APPLICATION BY HIGHWAYS ENGLAND FOR AN ORDER GRANTING DEVELOPMENT CONSENT FOR THE A47 BLOFIELD TO NORTH BURLINGHAM SCHEME (TR010040)

PROCEDURAL DECISION FOLLOWING ISSUE OF ACCEPTANCE DECISION

Further to our letter dated 5th February 2021 (**AS-001**) in response to your letter dated 2nd February 2021, I have set out below our responses to the remaining points you have raised.

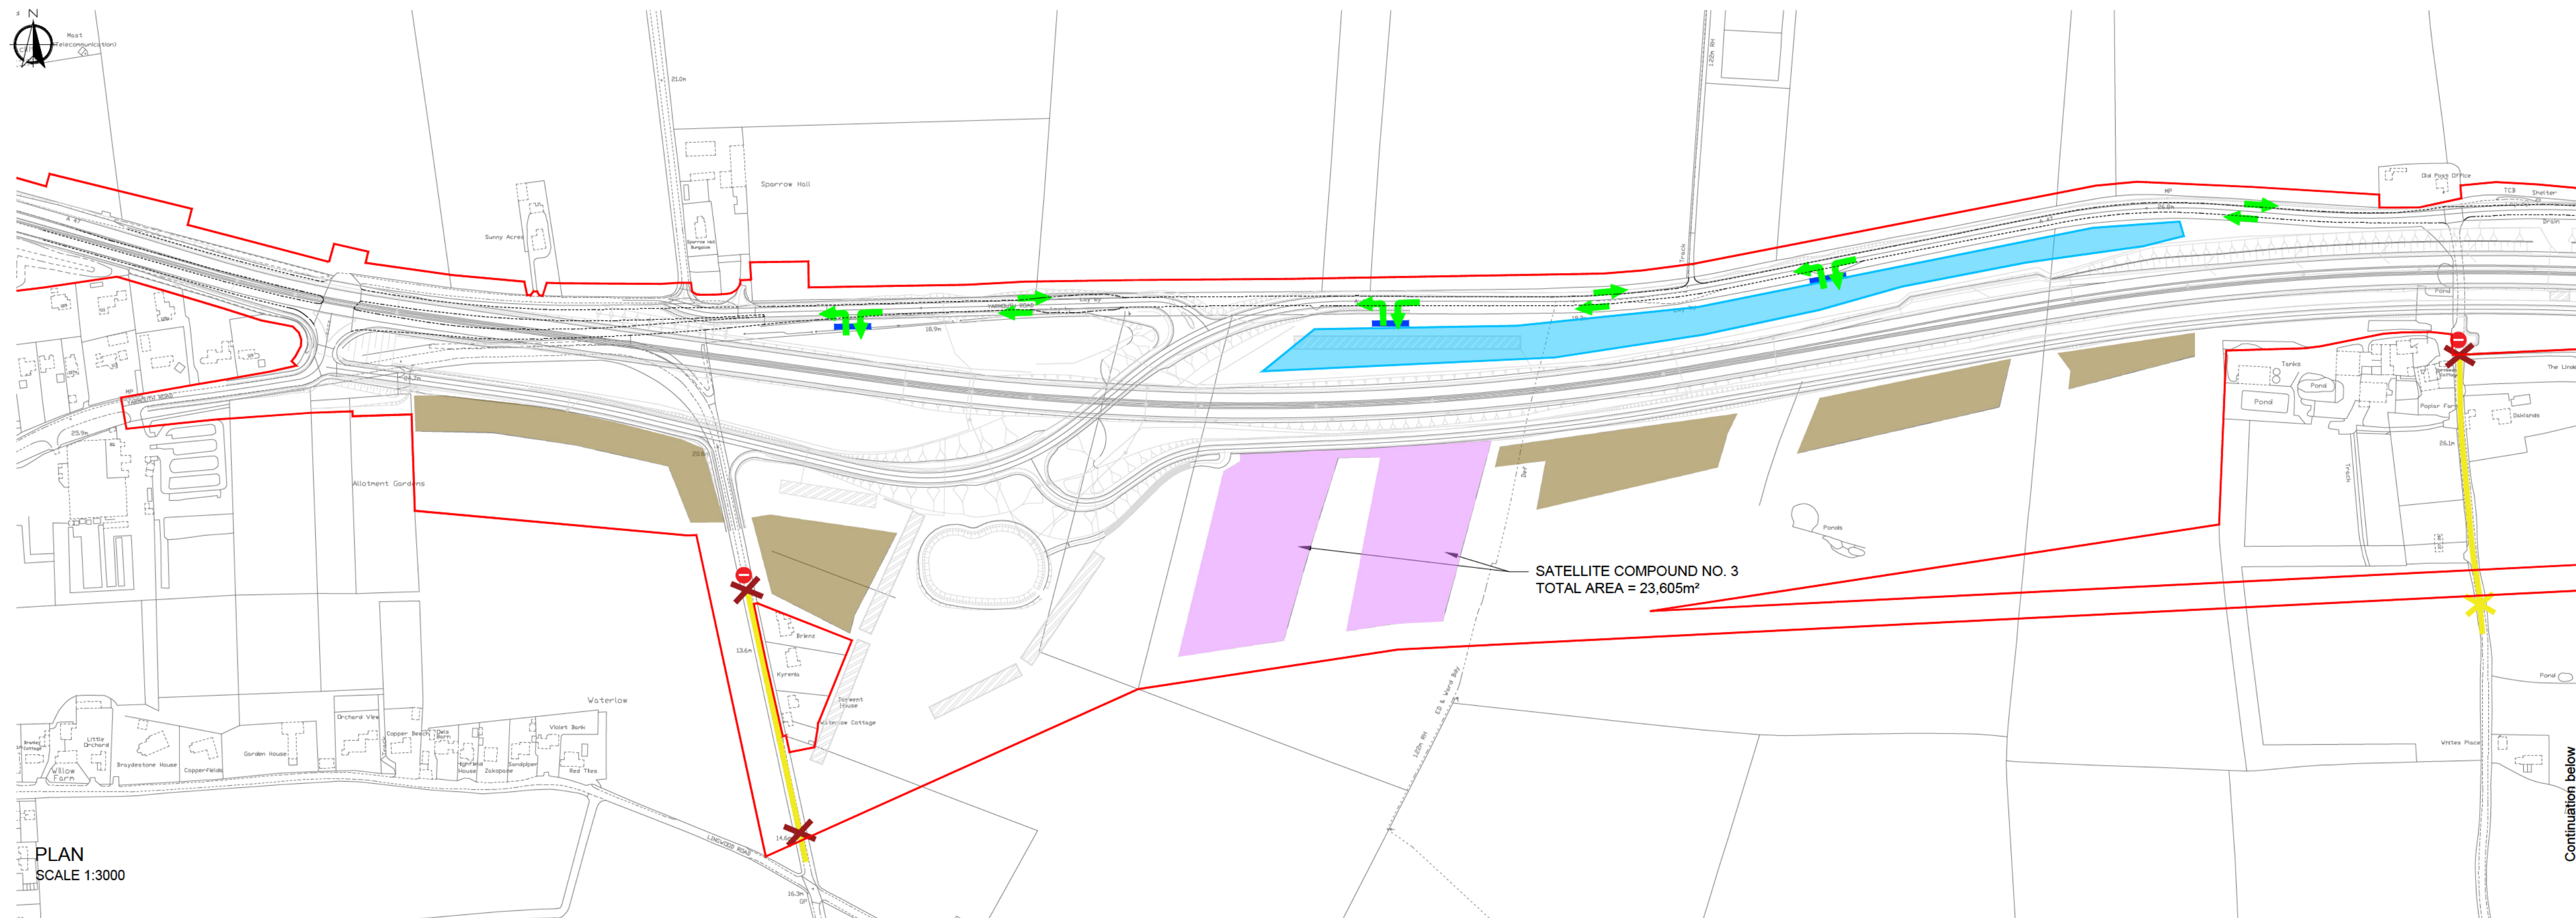
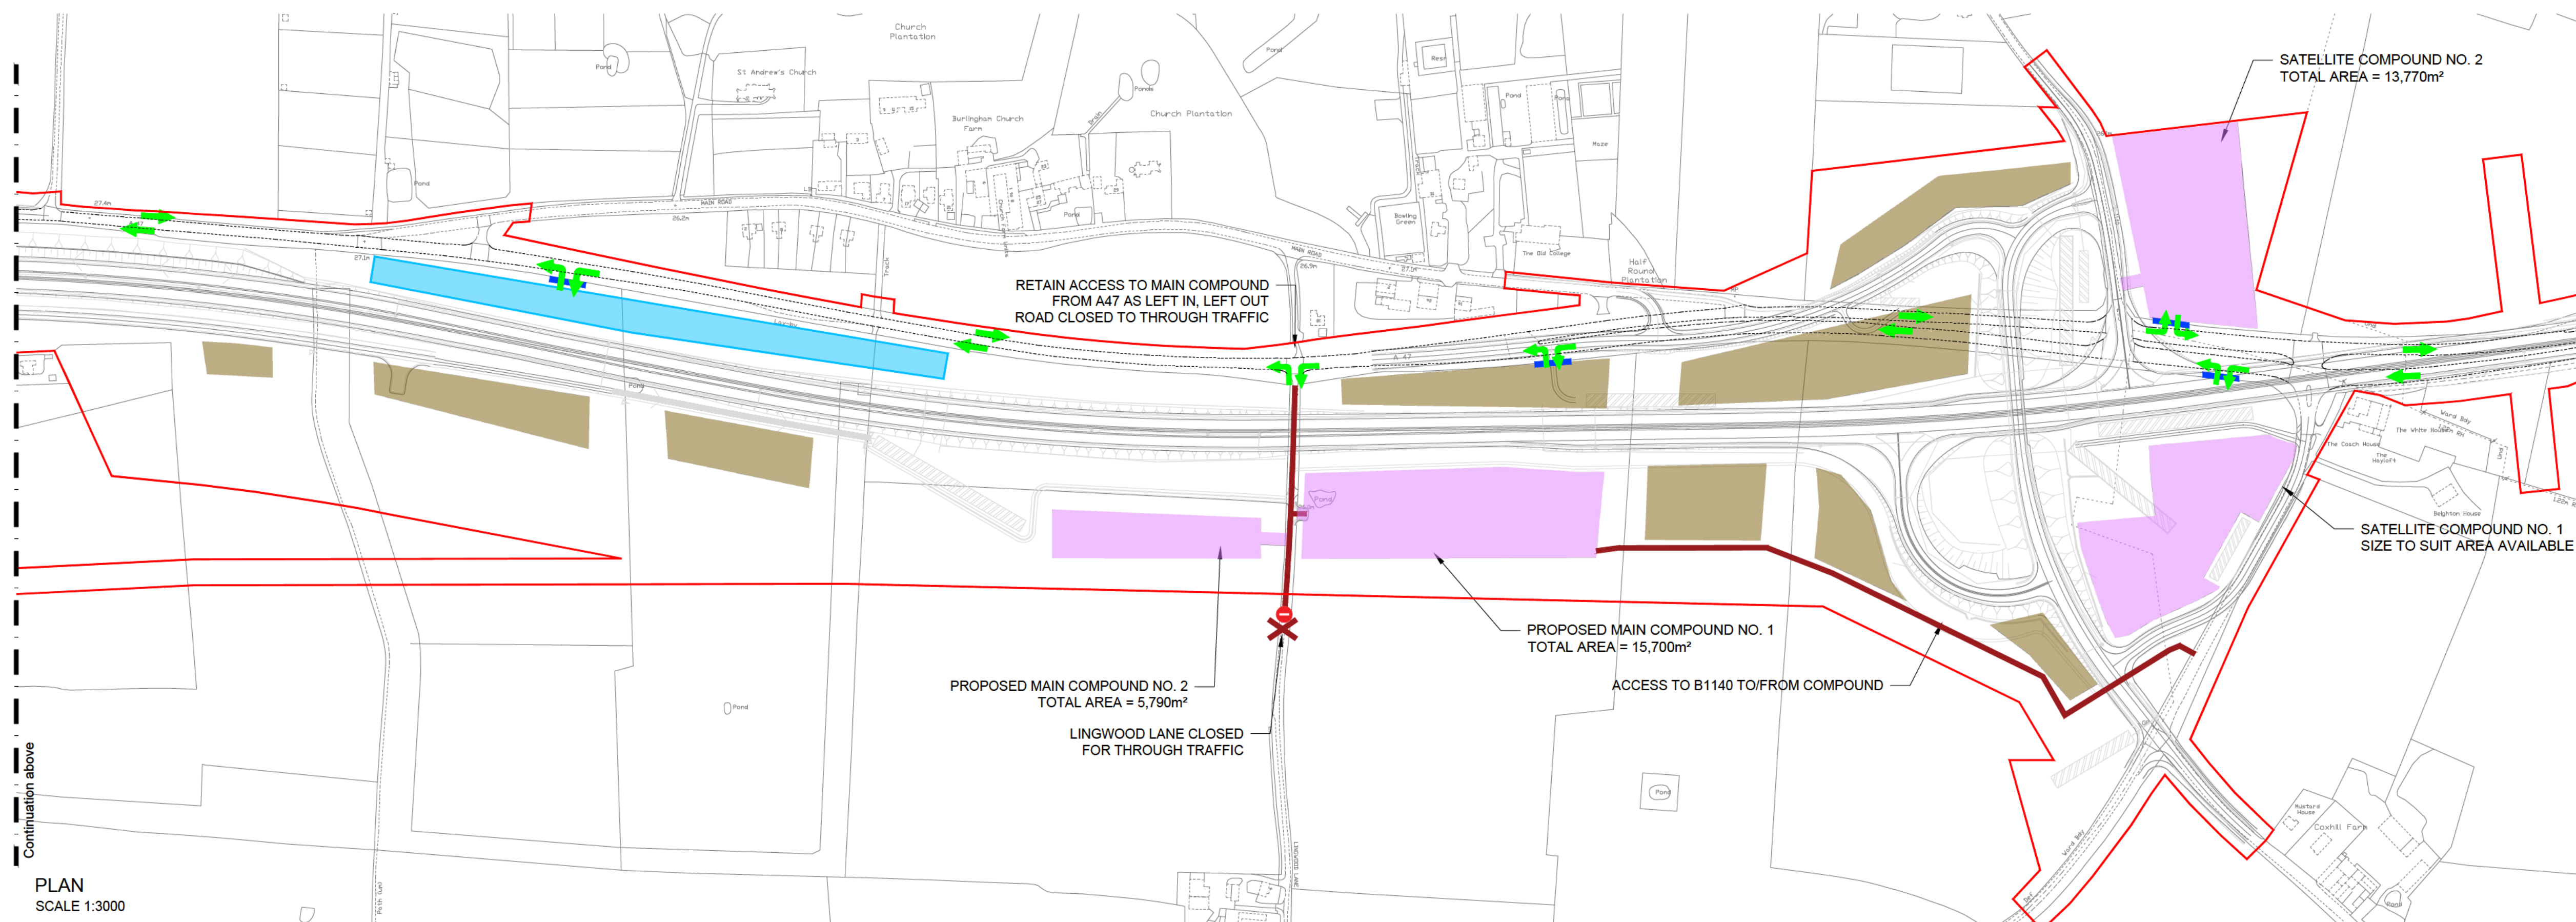
6. Outline Traffic Management Plan (OTMP) (TR010040/APP/7.8 (APP-125))

The Applicant can confirm that a plan identifying the envisaged routes for construction traffic and deliveries has been included in Appendix H of the revised outline Traffic Management Plan (Rev 1) submitted with this letter.
